## Recommendation Report

Application No.

Y/14/13

Existing Rear Elevation

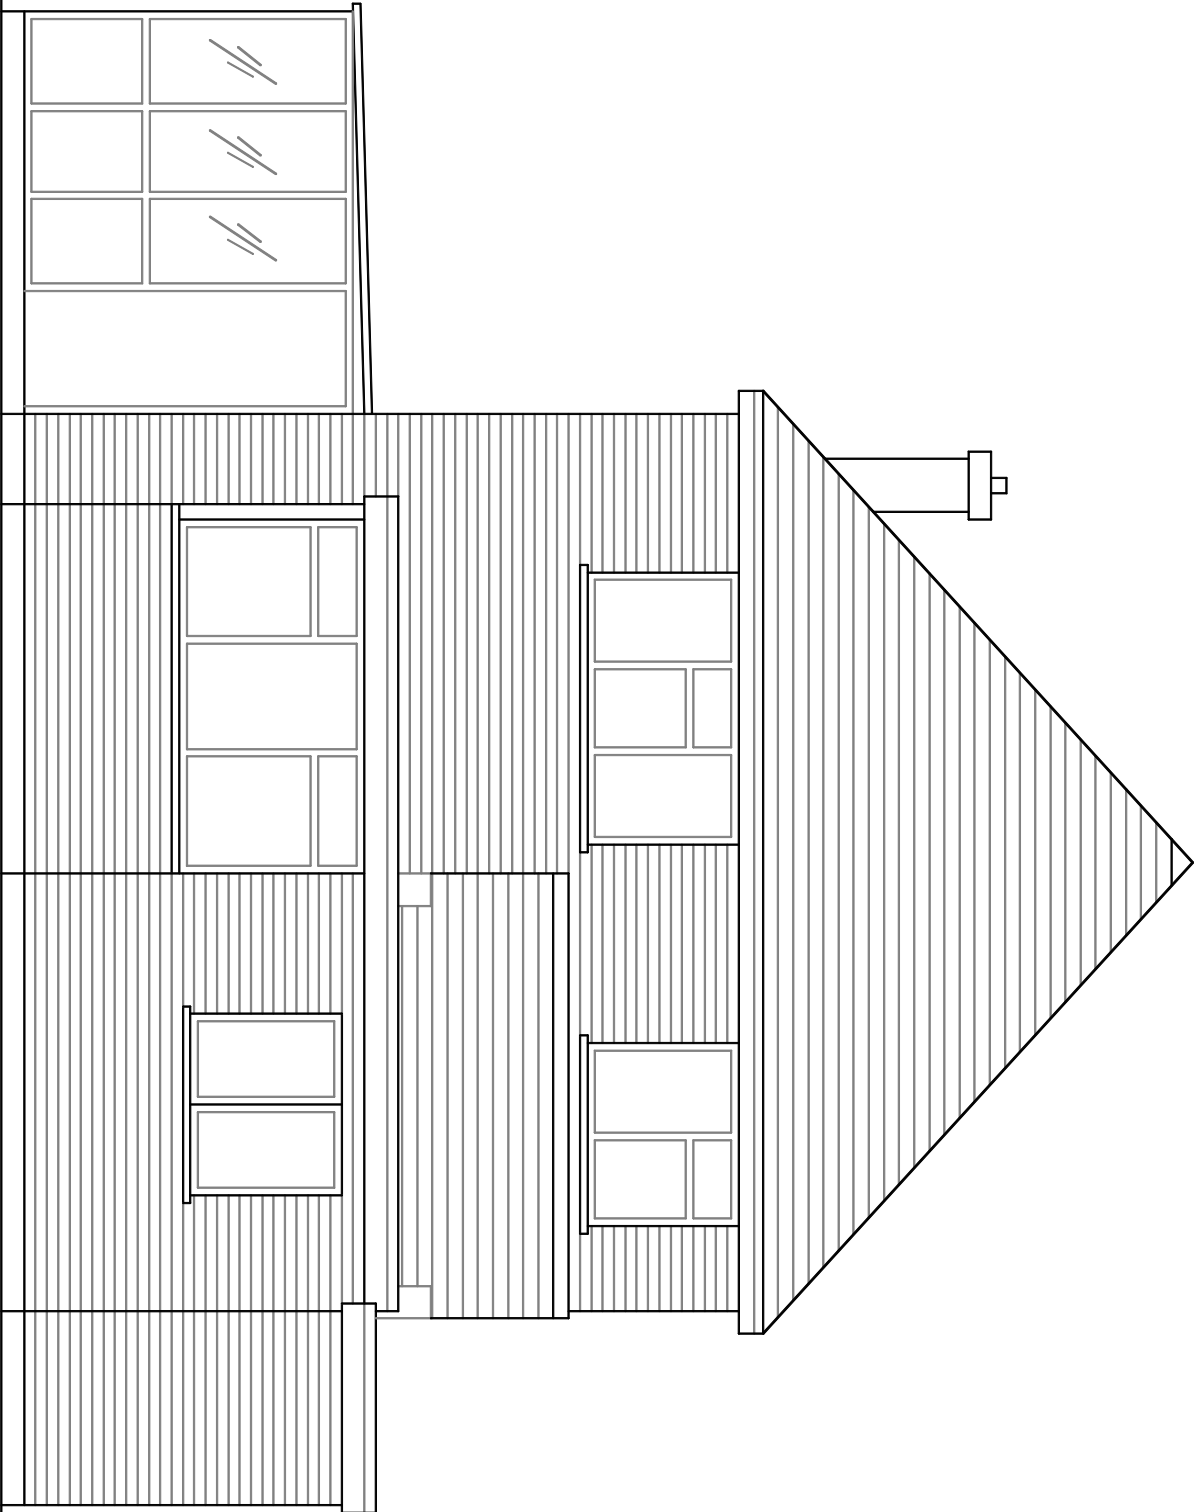
If you look at the last incomplete letter I sent you on 27<sup>th</sup> March 2013 and the first one I sent on 13<sup>th</sup> March 2013, I pointed out that the existing rear elevation does not accord with the existing rear floor plan.

I replied to this e-mail two weeks ago with the answers with this. The drainage is connecting to existing systems and can you tell me where you think there is a discrepancy in the drawing is as I can't see one. Please respond ASAP as this is taking too long to validate.

It's open because it's an opening if there was a door I would have shown one. This has now really held up the validation on the application through no fault of my own so can this now be hurried through

If you could correct it and send me a .pdf to me directly, I will be able to validate the application.
